SSD 7382 UTS Central, Broadway Precinct

Detailed Response to Submissions – July 2016

Drawing Title			
HYDRAULIC SERVICES			
DEVELOPMENT APPLICATION DETAILS SHEET			
FMU Project Number -			
Drawn By JH	Checked MS	Approved By PA	Date App. ---/---/---
Drawing Scale NTS	Drawing Status PRELIMINARY	AO	
UTS Drg File Name C802-HP53341	UTS Drg File No -	Rev No P2

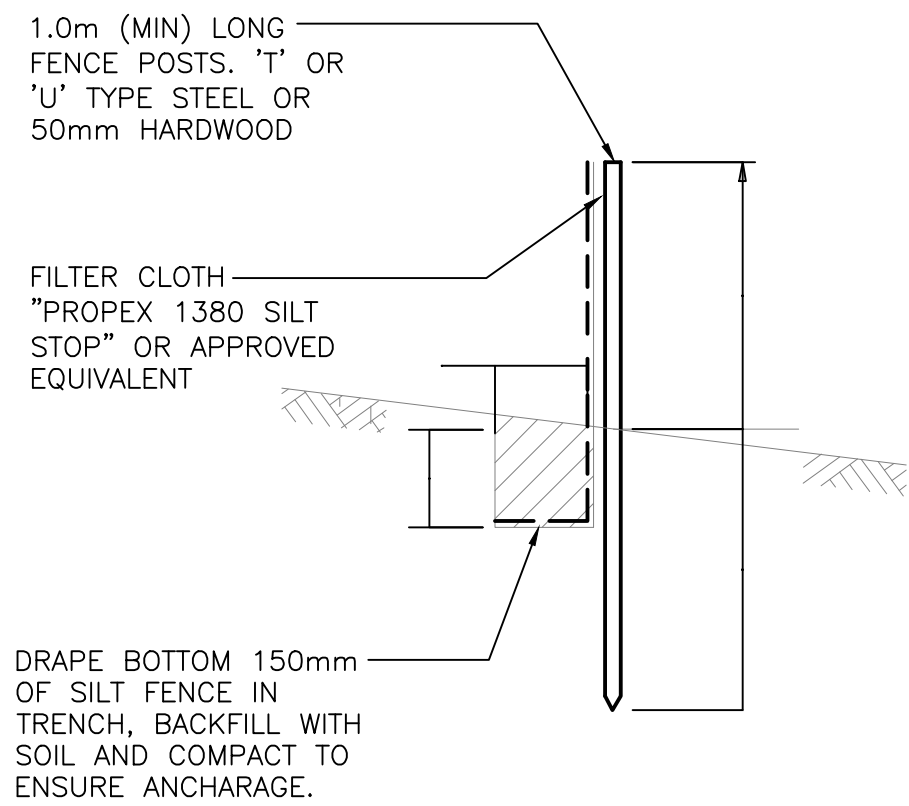
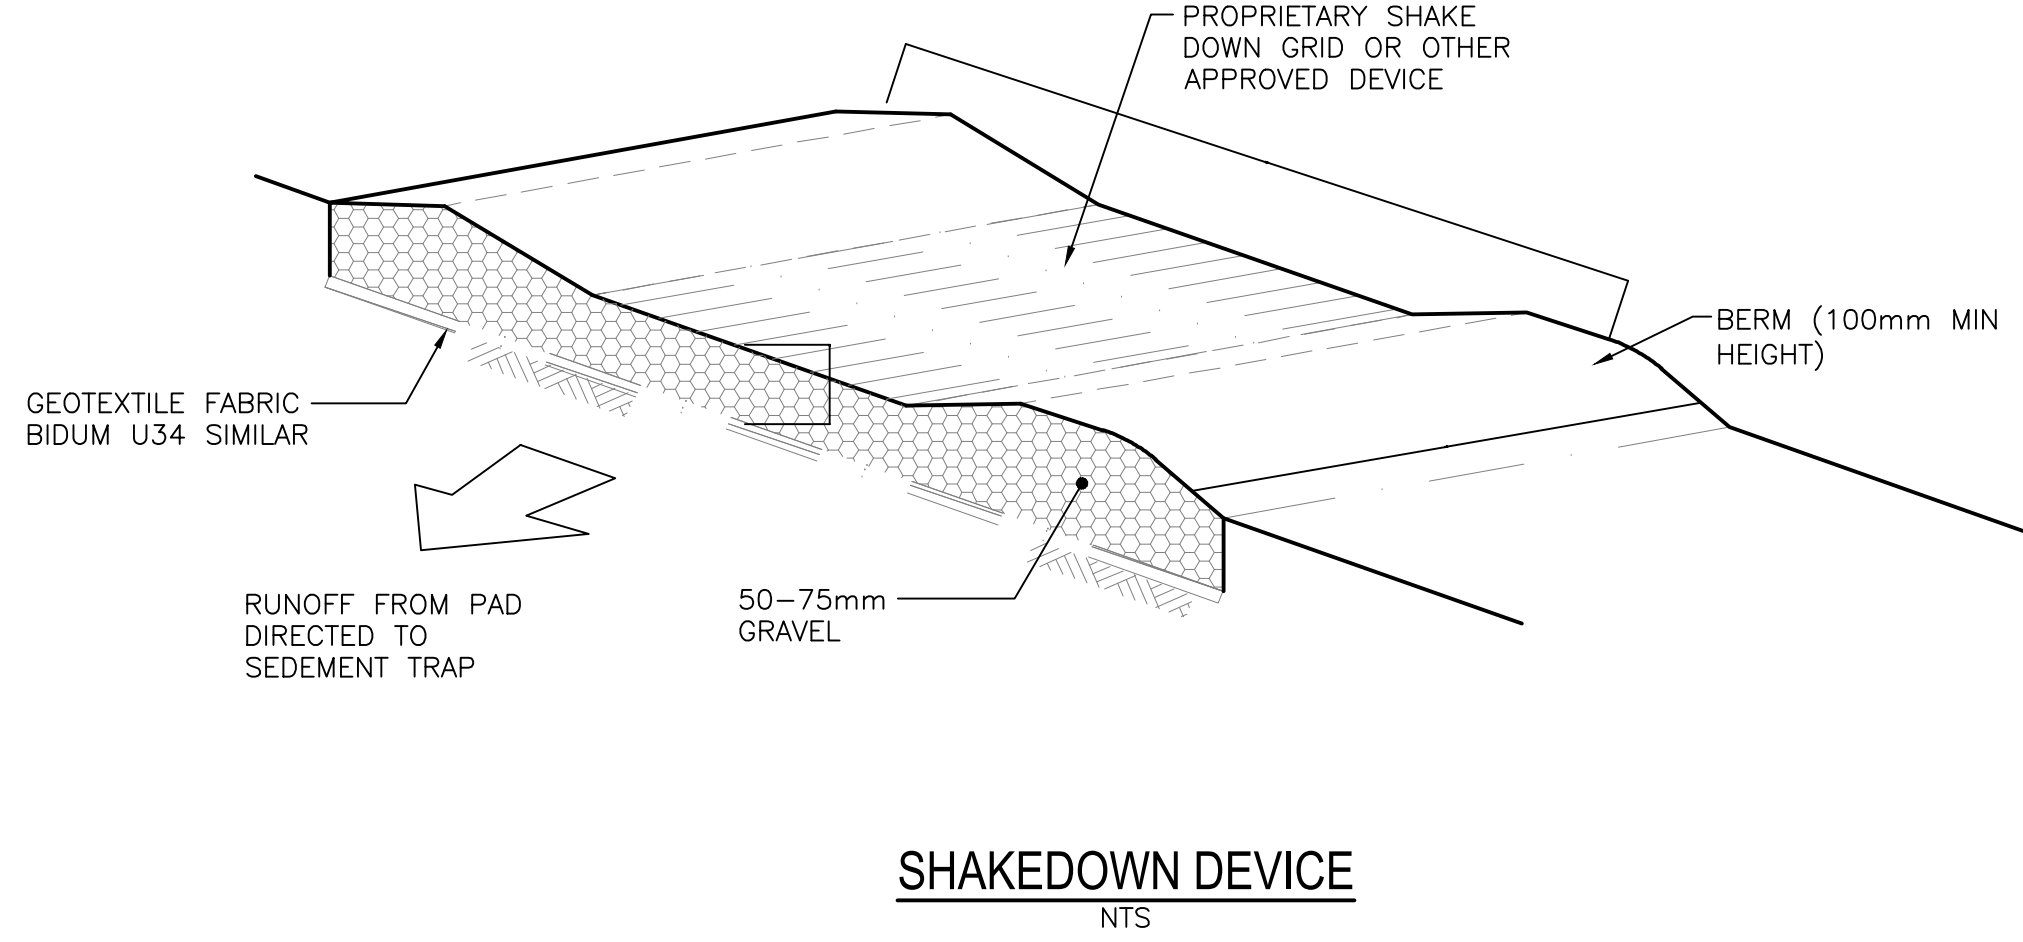
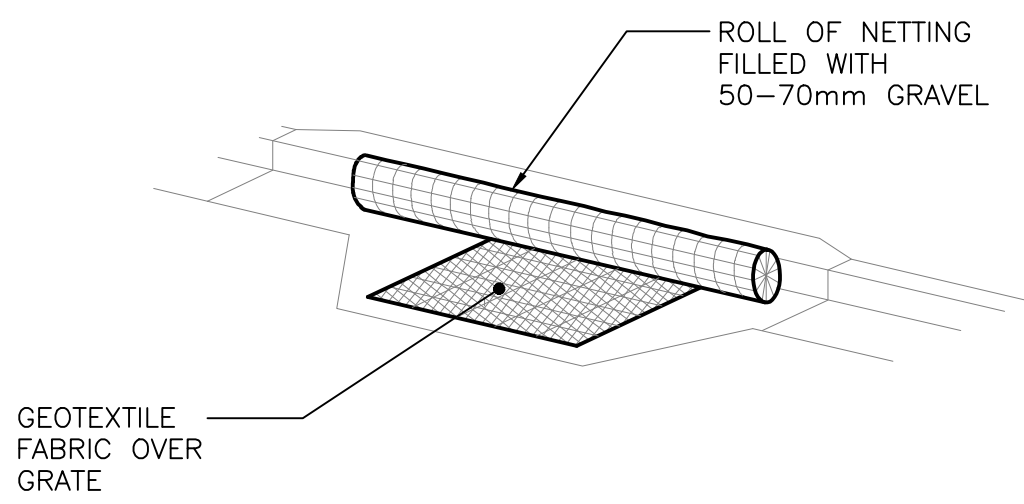
<p>Flooding</p> <p>6. An assessment of the existing and potential flooding impacts and potential flood planning levels should be provided.</p>	<ul style="list-style-type: none"> - As detailed within the Hydraulic Services drawings prepared by Erbas and submitted with this report (Appendix E), the PMF level has been determined as RL 5.22. This level has been plotted for reference on DWG no: CB0204-HP53334/P3. It shows each Flood Surface Level to be above that of the surrounding area Probable Maximum Flood Level.

Flood Levels Insufficient information has been provided in order to determine if the site is affected by flooding. Although a statement has been provided to confirm the site is not located at, or below flood levels, these levels have not been adequately quantified.		<ul style="list-style-type: none"> - As detailed within the Hydraulic Services drawings prepared by Erbas and submitted with this report (Appendix E), the PMF level has been determined as RL 5.22. This level has been plotted for reference on DWG no: CB0204-HP53334/P3. It shows each FSL to be above that of the surrounding area PMF.
Landscaping		
Tree Management Landscape Plans indicate new street tree planting along Broadway and Jones Street. The plans include species which are consistent with the City's Street Tree Master Plan (STMP). However, no detailed drawings have been provided demonstrating that new trees will be planted in accordance with the STMP. Accordingly, detailed plans should be submitted for consideration.		<ul style="list-style-type: none"> - New street trees are proposed along Broadway and Jones Street, the details of which will meet the City of Sydney Street Tree technical guidelines and can be conditioned accordingly.
